REPORT UPDATE

Application No: EP/136/18/PL

LOCATION: Tudor Lodge
125A Sea Road
East Preston
BN16 1NX

PROPOSAL: Variation of condition 2 imposed under EP/59/17/PL relating to approved plans concerning updated site plan & ground floor plan.

ROCCO HOMES
TUDOR COTTAGE, SEA ROAD,
EAST PRESTON
VEHICLE PATHS

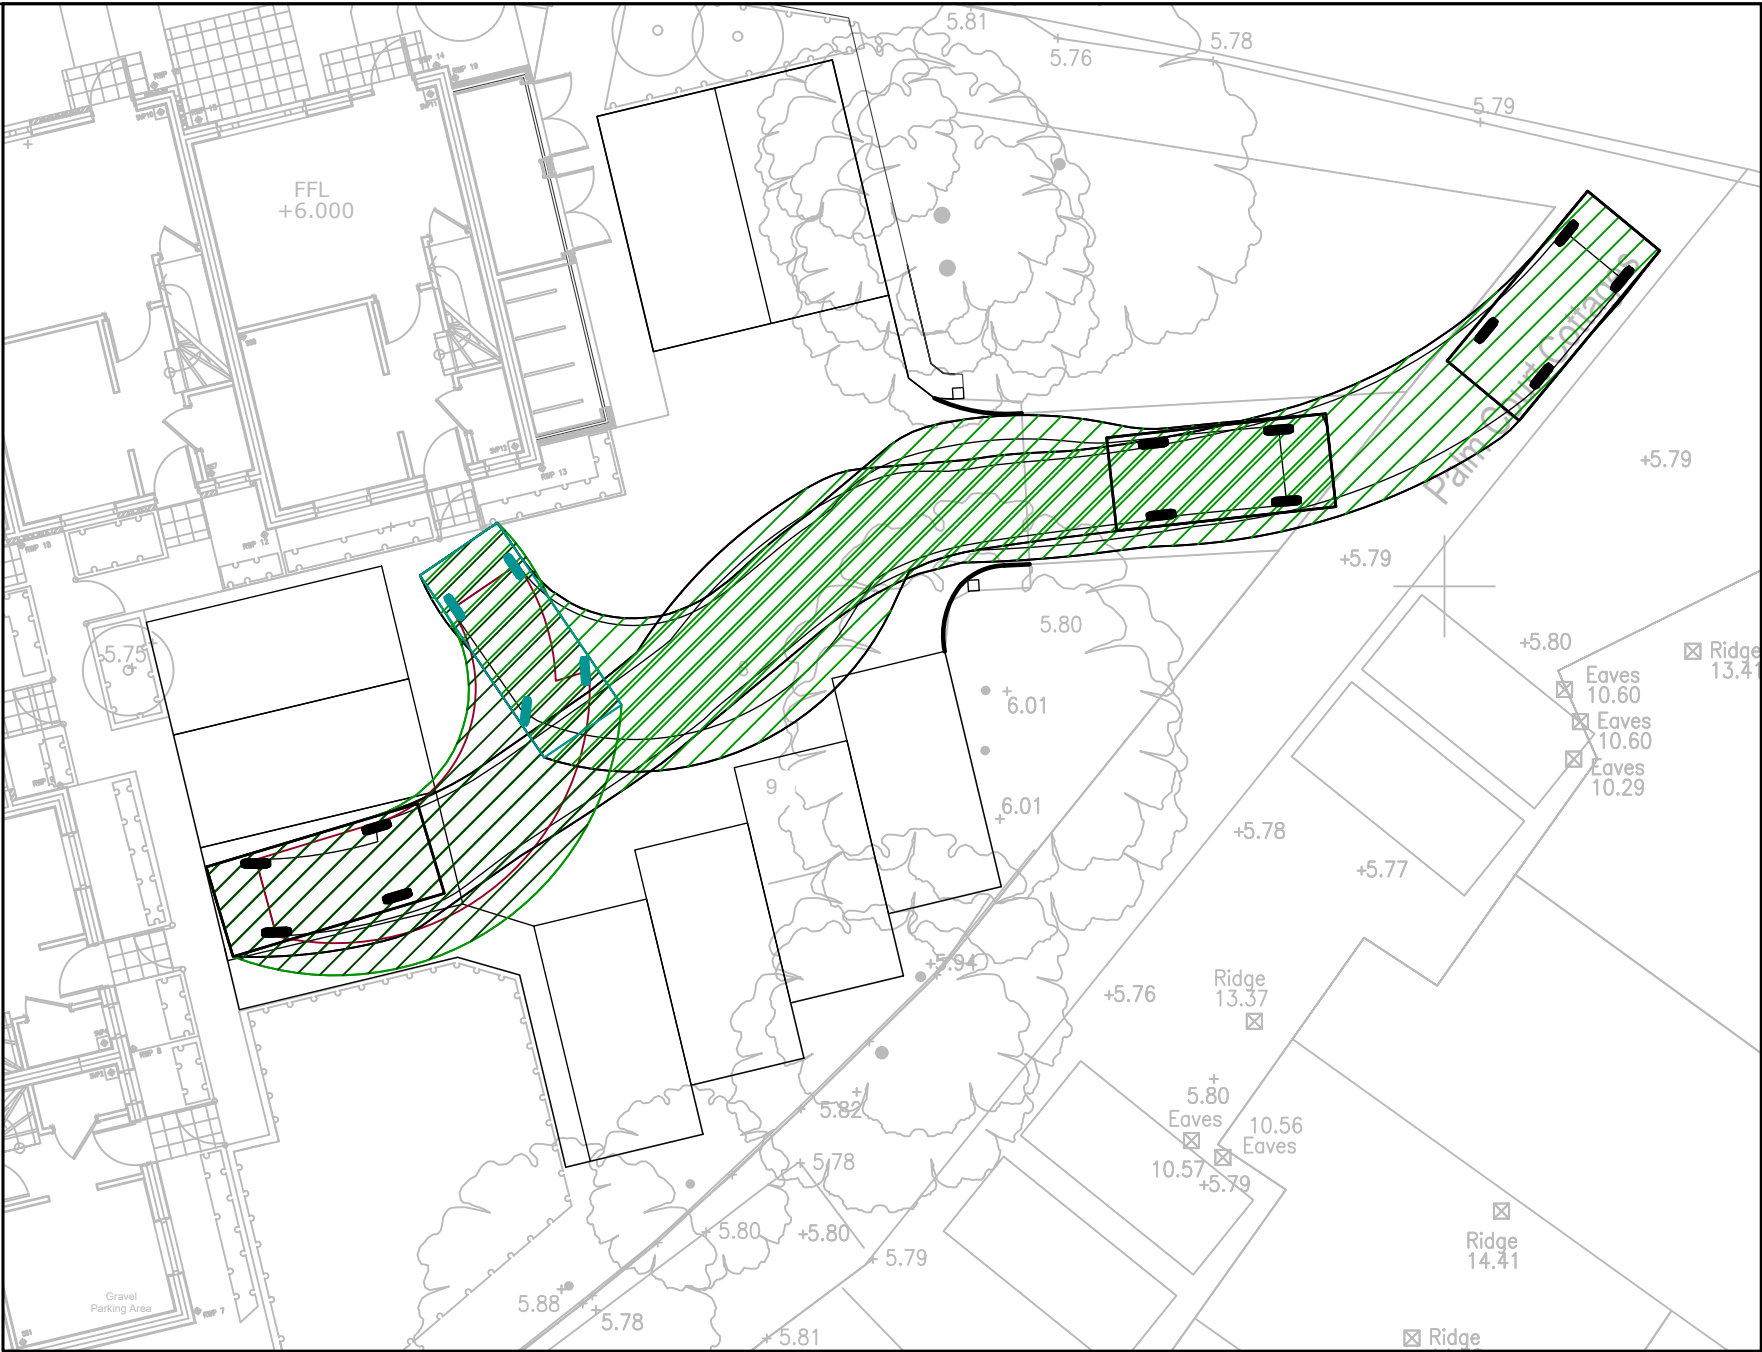
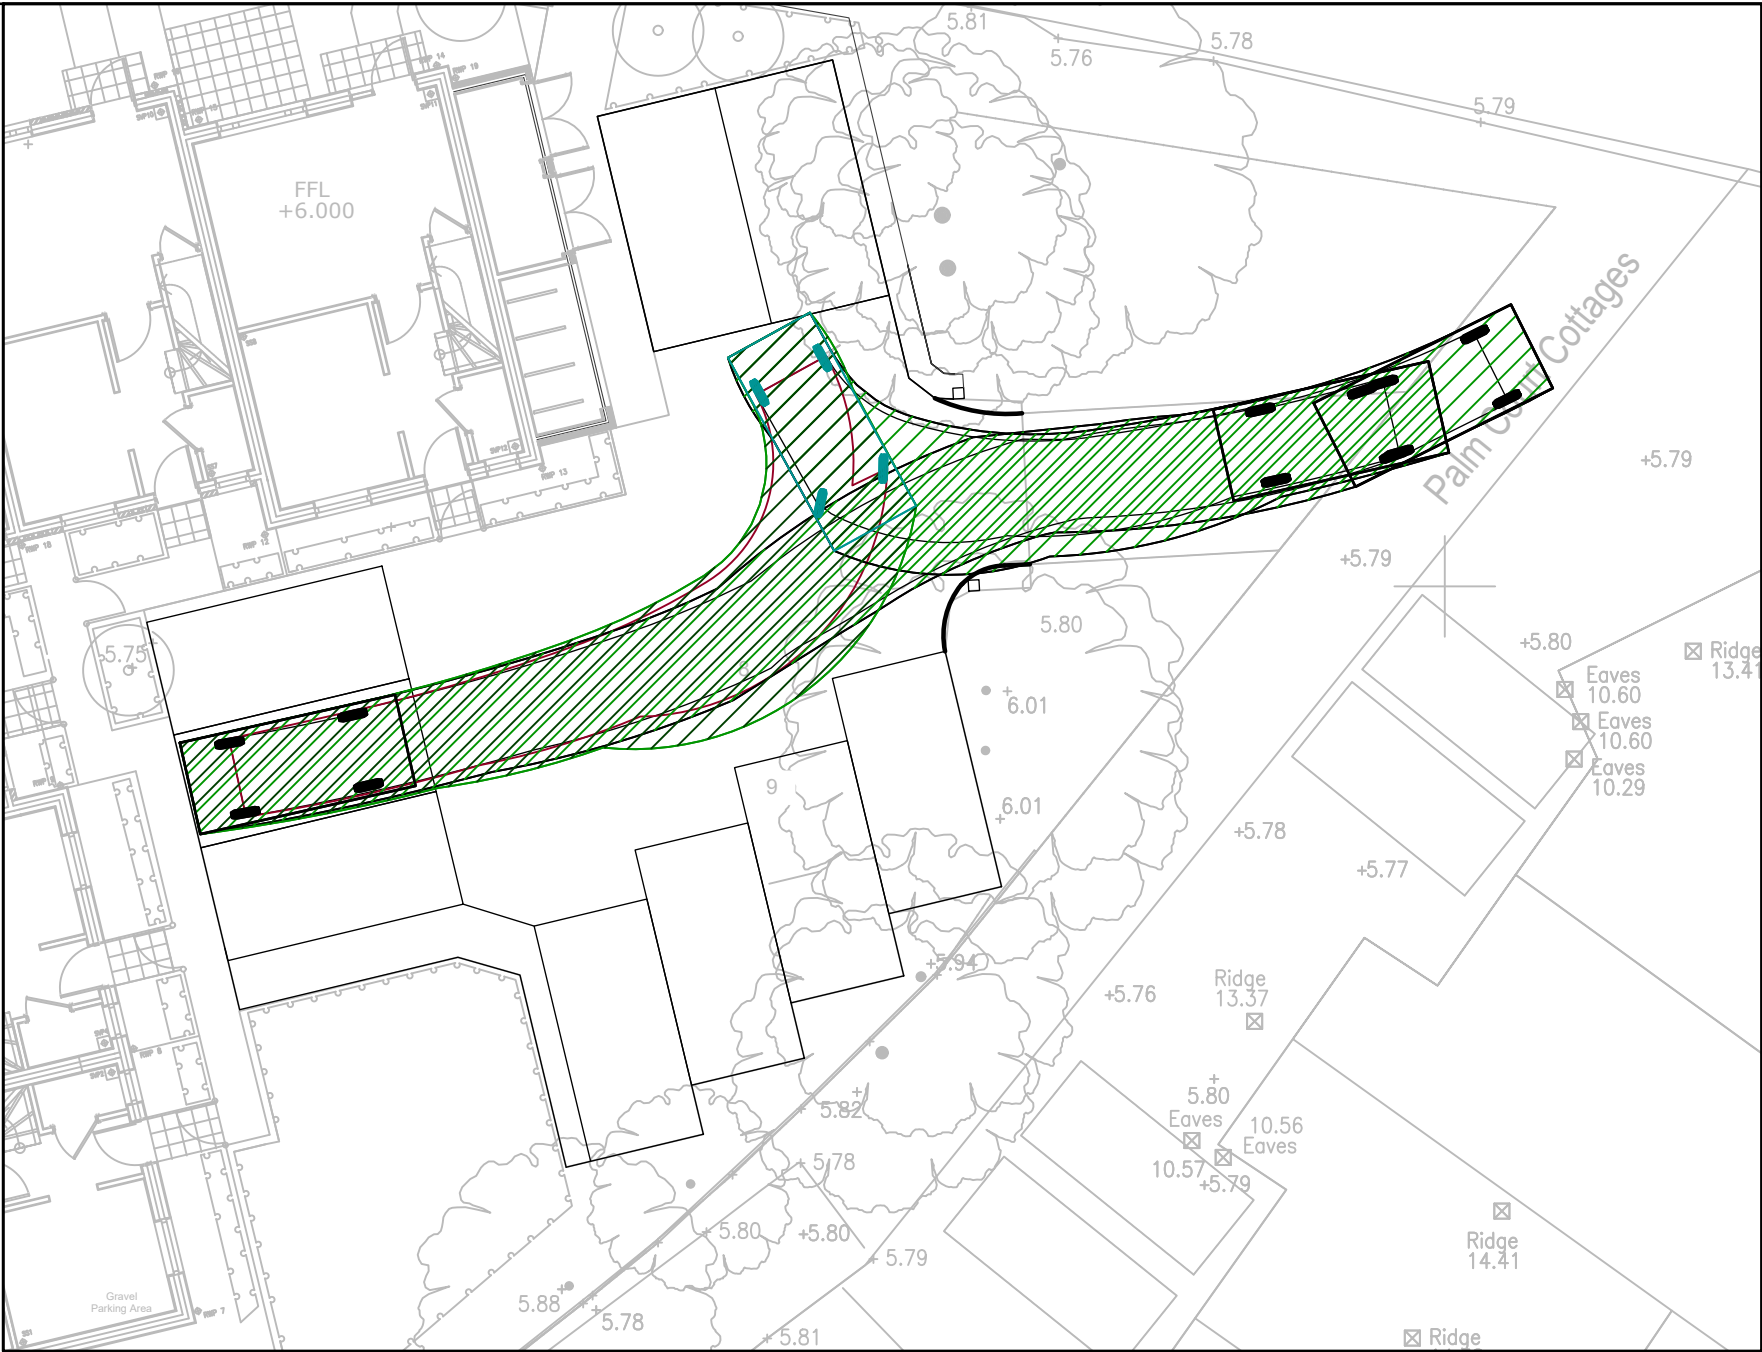
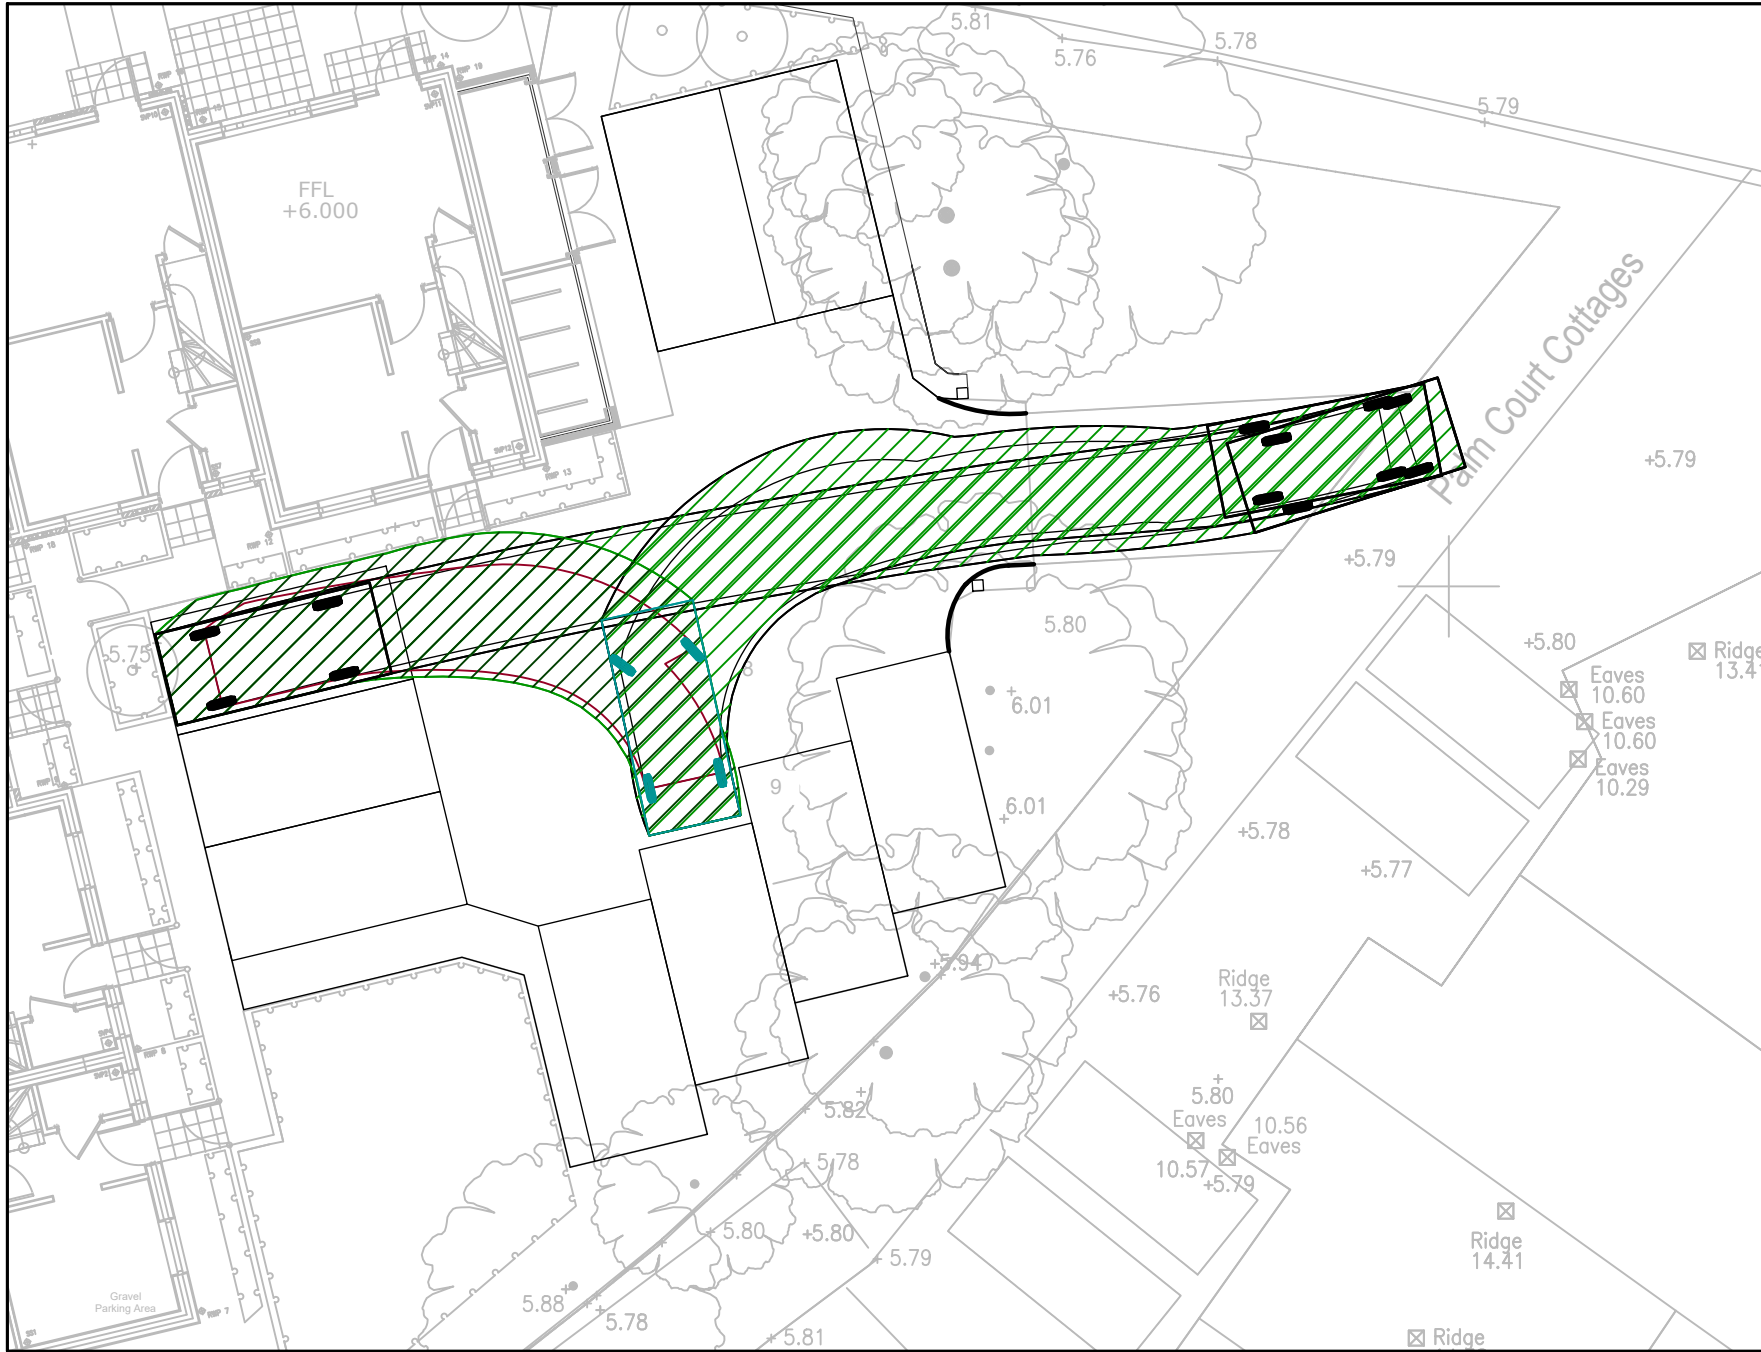
The agent has submitted additional plans which indicate swept paths for vehicles accessing the site and neighbour parking. The drawing has been fully tracked for all of the routes and spaces shown and is fully workable. The position of the entry point to the site remains unaltered. These plans have been submitted to address the concerns of third parties. For clarification purposes plan reference C-95-100 will be removed from condition no 1 and replaced with one that reflects access out onto South Strand. The plan is in the process of being prepared. Condition no 1 will be amended to reflect this possible access. However, if traffic was to access onto Palm Court Cottages this would be a private matter outside of planning control.

County Highways - No Objection. There are no changes to access or the amount of parking spaces. The parking area has been reconfigured. Tracking has been provided to demonstrate that the layout is workable. WSCC would raise no highway safety concerns to the proposed change.
